**Consultation Response from KC,  
Lead Local Flood Authority**

**2025/93229 Land off, Westgate, Cleckheaton, BD19 5DR**

**Discharge of details reserved by conditions 15 (drainage), 33 (waste), 37 (cycle parking), 41 (LEAP) on previous permission 2021/93567 for demolition of existing commercial buildings and erection of 180 dwellings with associated works**

**Date Responded: 30<sup>th</sup> December 2025**

PENSTOCK DETAIL

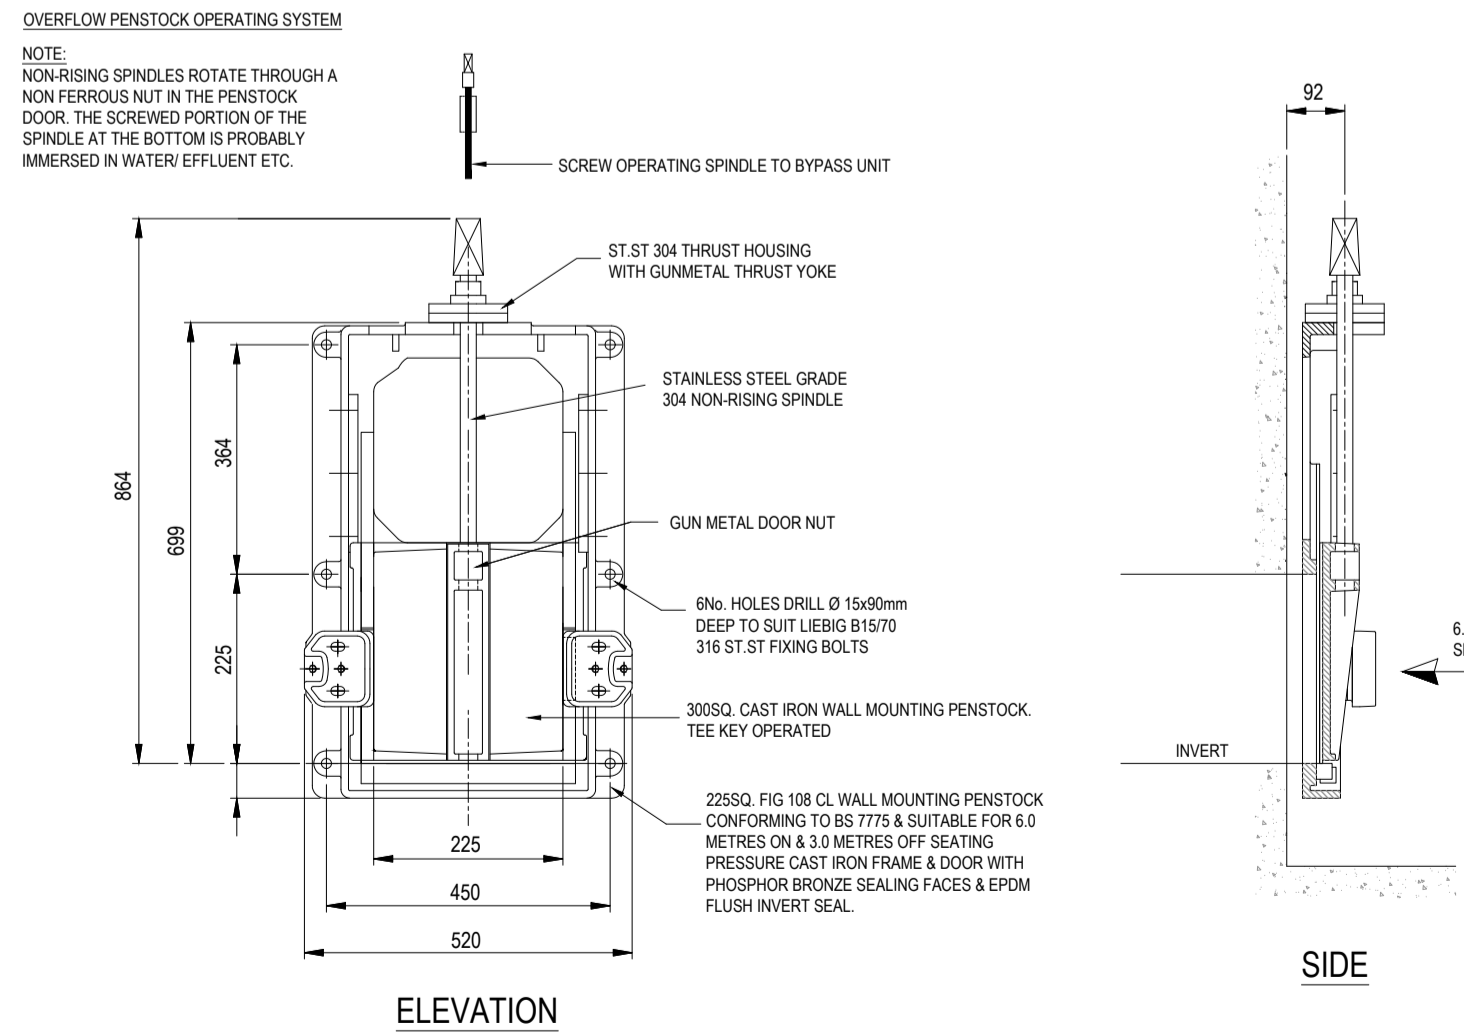
For the flow control device, the penstock will likely need greasing periodically to ensure it does not stick. The flow control device may need to be removed at some point, and the neoprene seal must be replaced at this point. Sumps must be cleared periodically and the methodology and plant required must be stated.
